Fw: EN010127 Field 18, Mallard Pass Solar Farm

Subject: RE: EN010127 Field 18,

DRAWING TITLE
Figure 5.1(c) Fixed South Facing Central Inverter Illustrative Development Layout

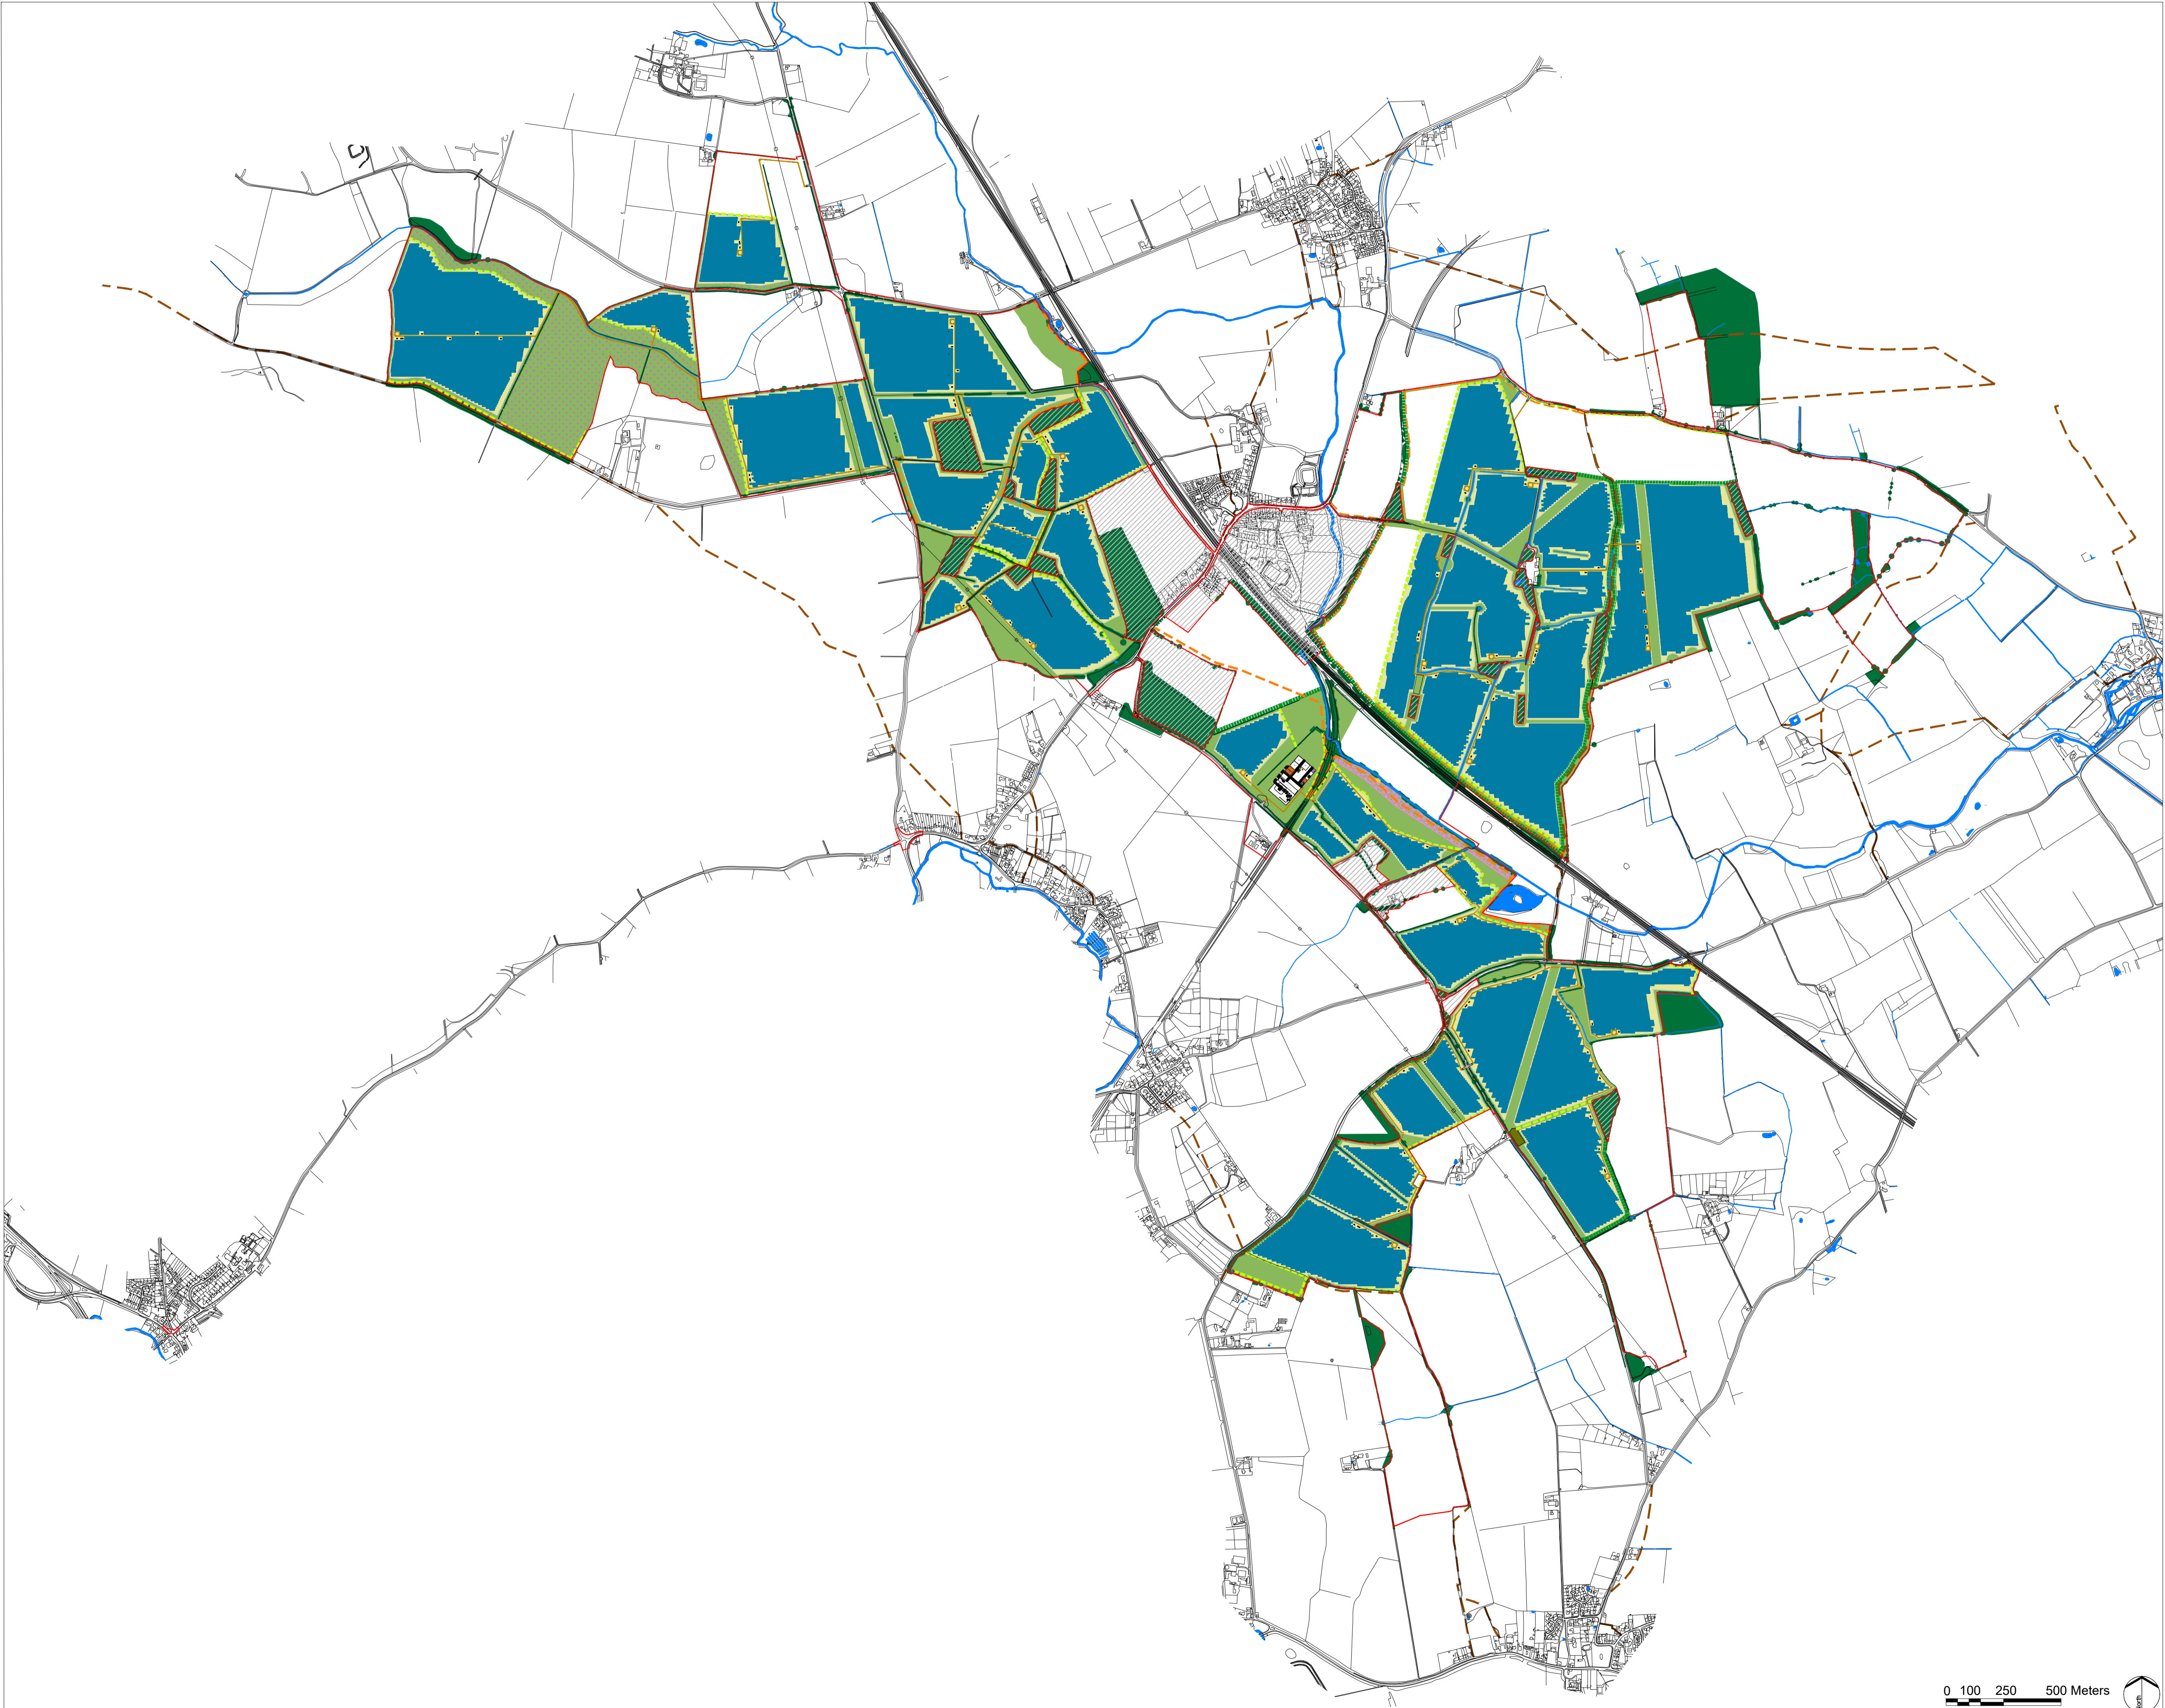
Following REP05-058 I'm asking if field 18 which is West of the East Coast Main Line and will be used during the construction stage of the proposed solar farm as a parking/construction area can have the PV arrays removed based on the following point.

- 9 Glen Crescent has views across field 26, 18 & 19 internally from downstairs Kitchen, Lounge and Conservatory windows so PV arrays in field 18 will be visible internally 365 days a year.

- Other properties in Glen Crescent also have gardens backing onto field 26 with views over fields 18 & 19.
- The PV mounting structures will be what residents view so field 18 will have the appearance of a field of scaffolding and not glint and glare

- The proposed mitigated planting on the boundary between field 26 and 18 will not mitigate the view of the PV arrays mounting structures as the field elevates up and away from the planting line when looking south from the village, the field faces north.

Field 18, No PV arrays should be built in this field it should either be left arable or planted as meadow

Q. Why can't the PV arrays be removed from field 18 as has been done in other areas of the site

You refer to the Applicant's [Residential Visual Amenity Assessment](#) (RVAA) [APP-057] where Glen Crescent is recognised as a specific receptor group. The RVAA recognises the potential impacts and comments on how the design evolution has sought to address potential impacts by removing panels from Field 26. The RVAA also points to the planting along the boundaries of Fields 18 and 19 and concludes that the magnitude of change would be negligible with a slight adverse impact. The Applicant has further responded to concerns relating to visual amenity from Glen Crescent in the [Applicant's Response to Interested Parties' Deadline 2 Submissions – Landscape and Visual](#) [REP3-032].

In response to your specific point around the ECML, the solar PV area in fields 27 and 29 was moved to provide a greater set back from Essendine, further respecting public amenity of the residents of Essendine and mitigating visual impacts of users travelling along the A6121. The combination of the dis-used railway line, topography and existing underground utilities offer structuring elements within in the landscape, with the proposed solar PV area being designed to sit to the east of Essendine to reduce the potential impacts in accordance with the design principles set out within the the Design and Access Statement (DAS) [REP5-058]. The Applicant's response to potential impacts has sought to work on a bespoke basis, noting that an appropriate measure for one area of the Site may not result in the same outcome somewhere else so it is not necessarily a matter the solar PVs being a certain distance or using a certain feature to the achieve the same effect. In the case of Glen Crescent, the Applicant has identified measures it feels are appropriate in the context of the landscape and assessed impact and these must be balanced against a range of other factors including the urgent need for renewable energy generation.

DRAWING TITLE
Figure 6.11: Green Infrastructure Strategy Plan

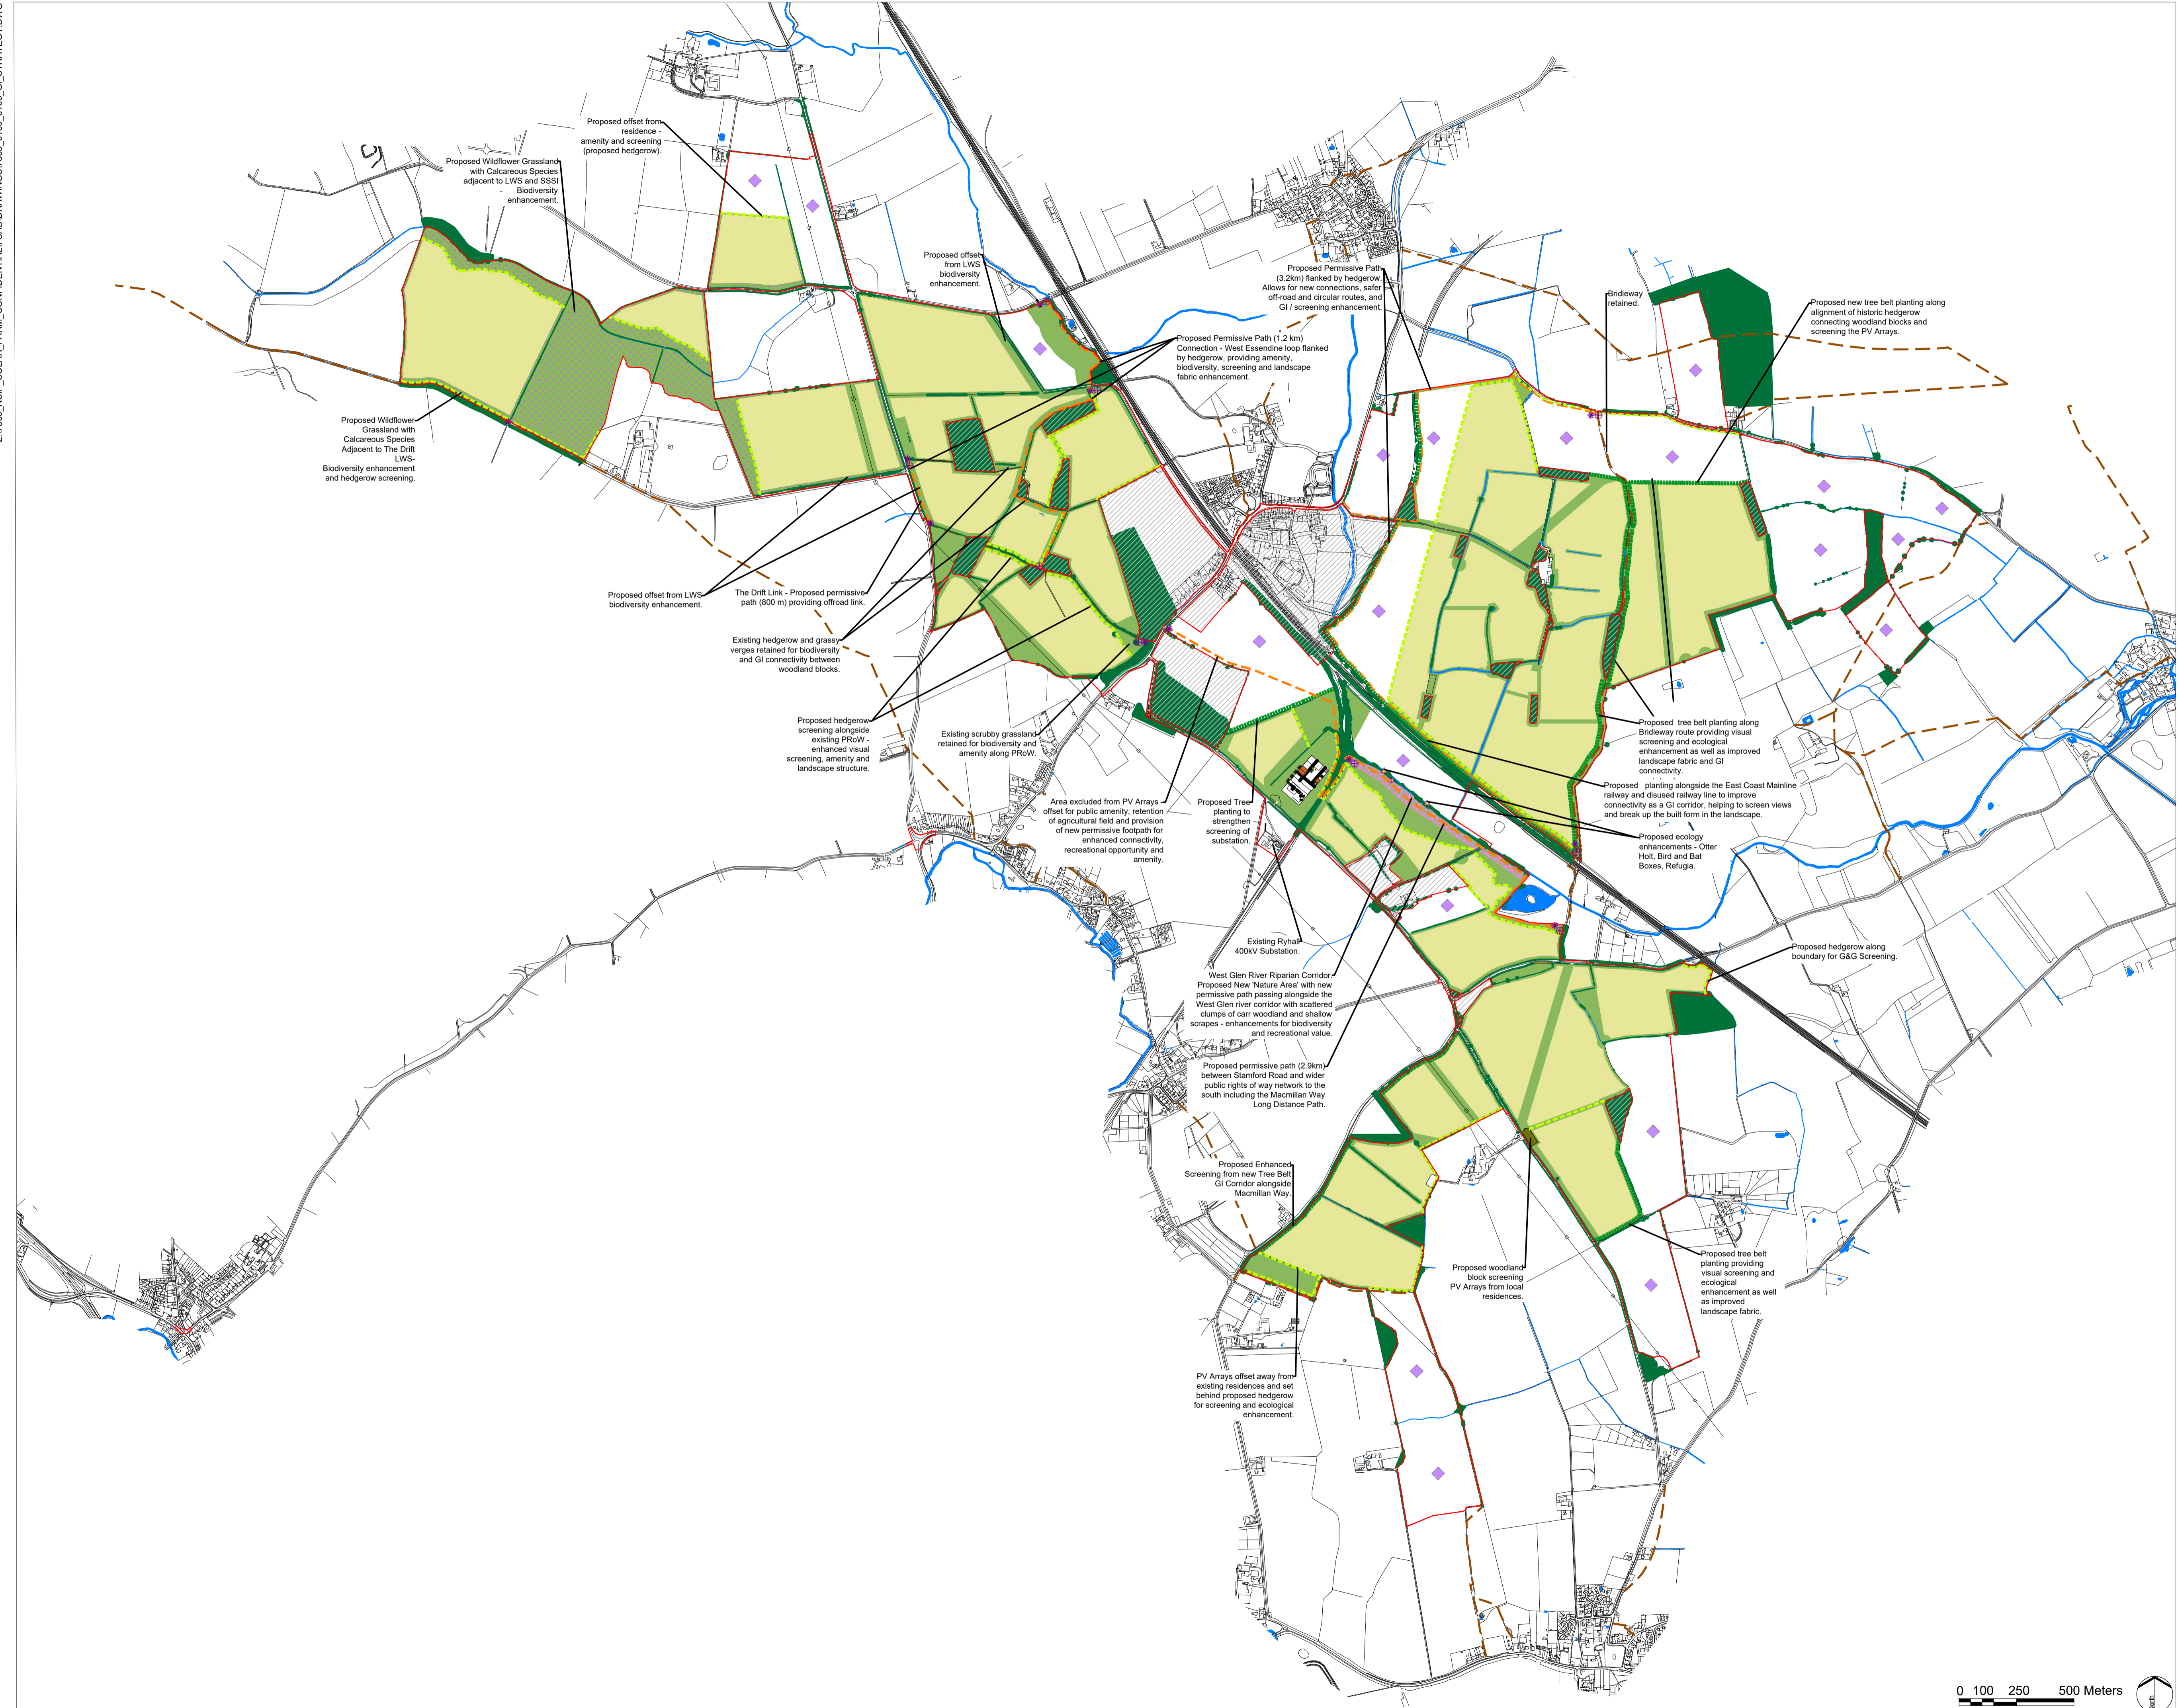
REP7-021 is either wrong or the original concept plan presented at stage 1 at the start of the process is wrong, no PV arrays were ever being proposed for field 26 it was always a mitigation and enhancement area and retained for agricultural use
